# CITY OF PORTLAND

# BUILDING PERMIT

Job ID: 2011-08-2122-ALTCOMM

has permission to Replace a section of rotted guardrail

UNIT #2 FROM PLOT PLAN

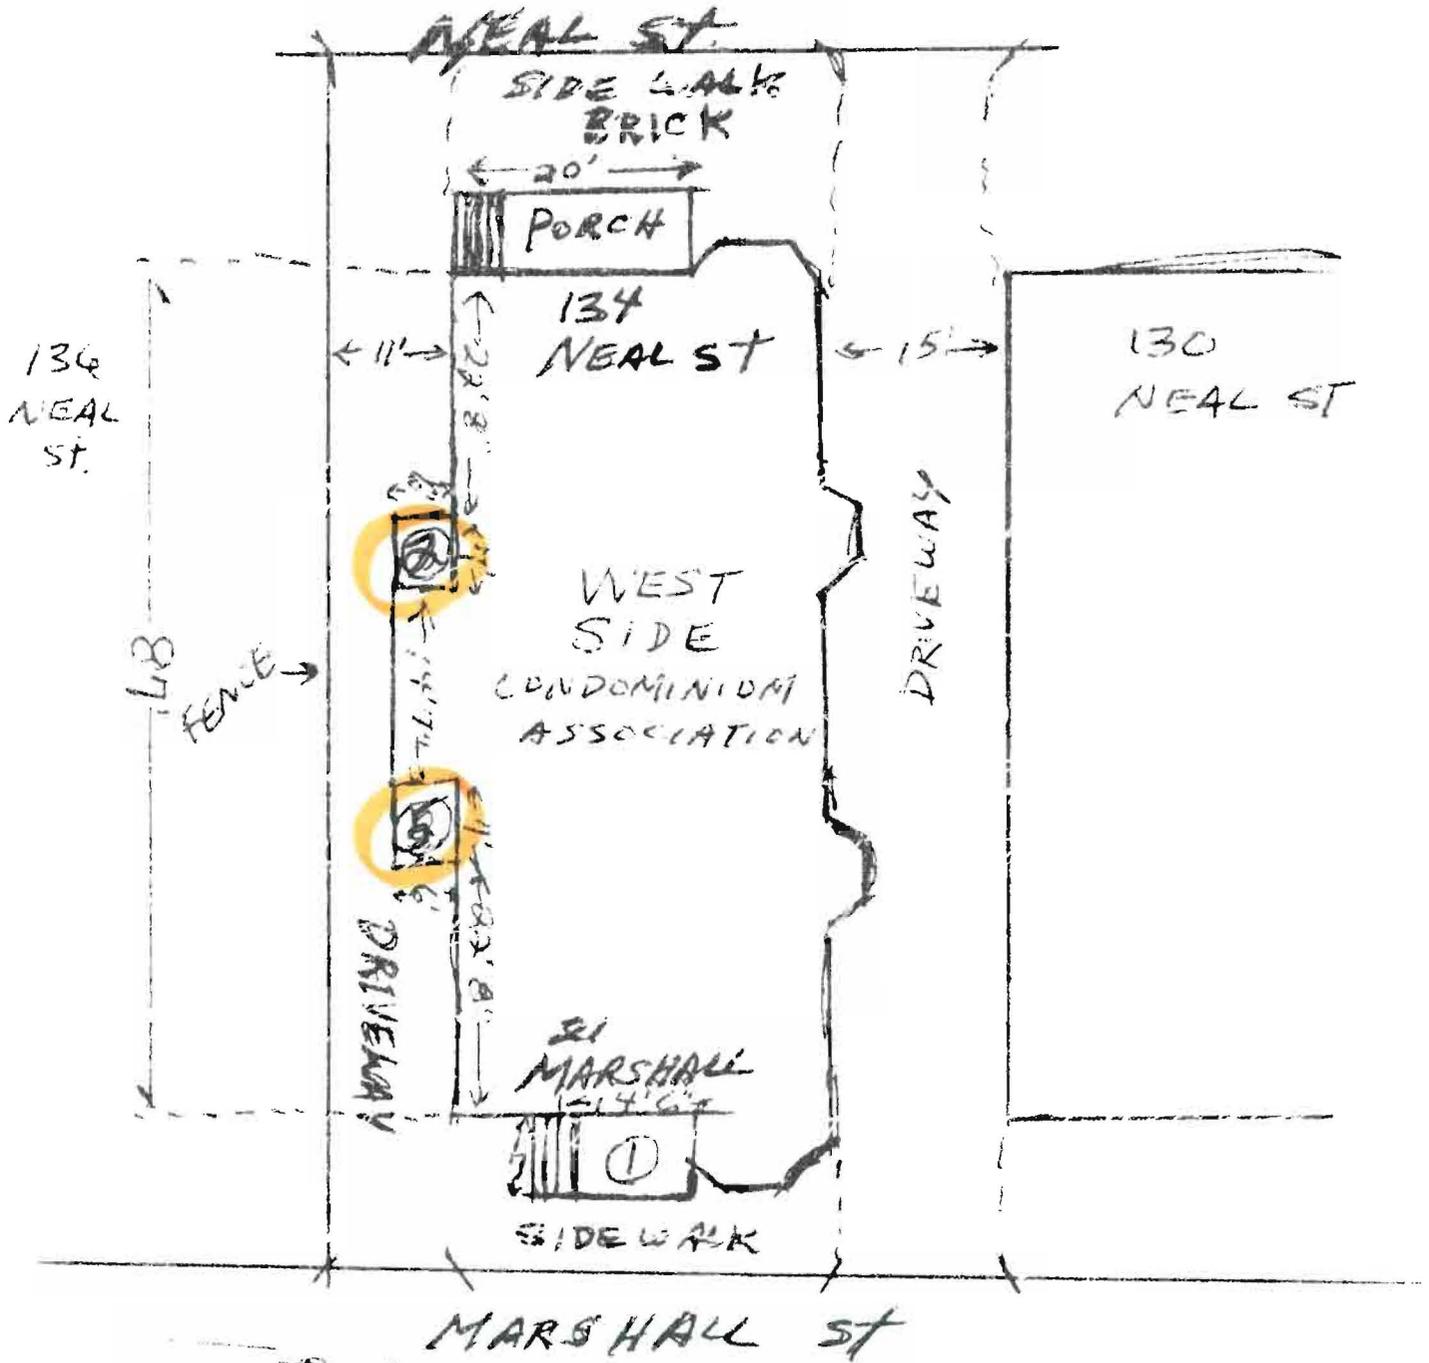
1. Height of railings not to exceed 36" to be consistent with traditional porch railings and proportionate to existing building.

1. Application approval based upon information provided by applicant. Any deviation from approved plans requires separate review and approval prior to work.
2. This permit is approved per IBC 2009 Section 3409.1 for guardrail height allowance to be 36"

Historic Preservation Committee Staff Recommendation: Staff don't see  
support 42" railings in this  
context - recommends 36"  
 Inspections Staff Recommendation: OK for 36" HT
